OUT17/37666

Transport Assessments  
NSW Department of Planning and Environment

**Sydney Metro City & Southwest (Sydenham to Bankstown) SSI 8256  
Comment on the Environmental Impact Statement (EIS)**

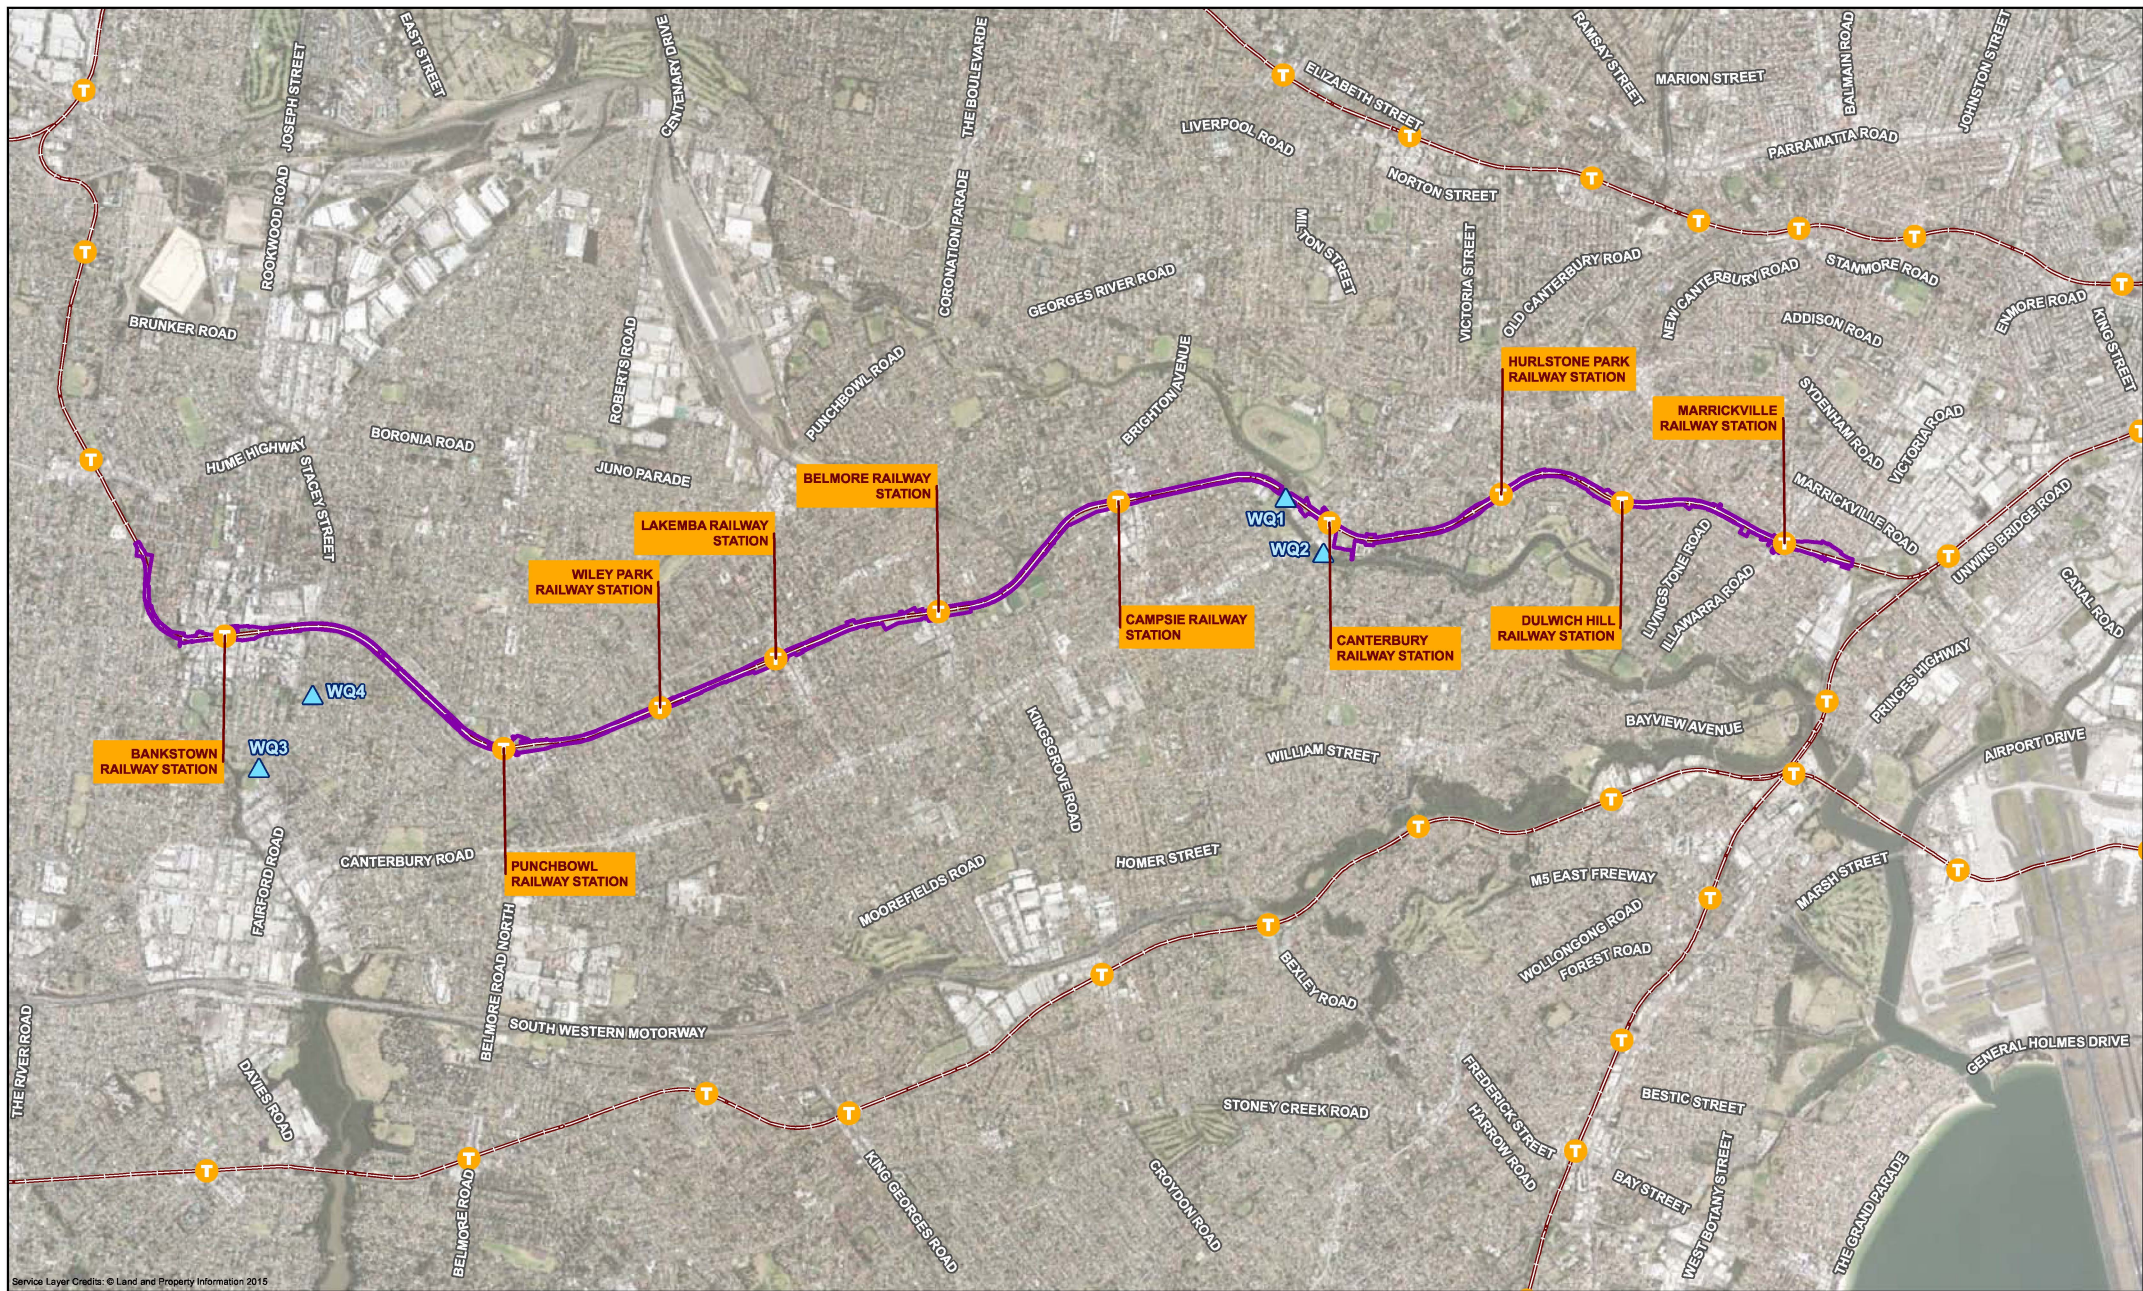
- A surface water quality monitoring program should be developed for the operational stage of the project and undertaken over a two year period.
- To reduce potential impacts on the aquatic environment, best practice erosion and sediment control measures should be used during construction.
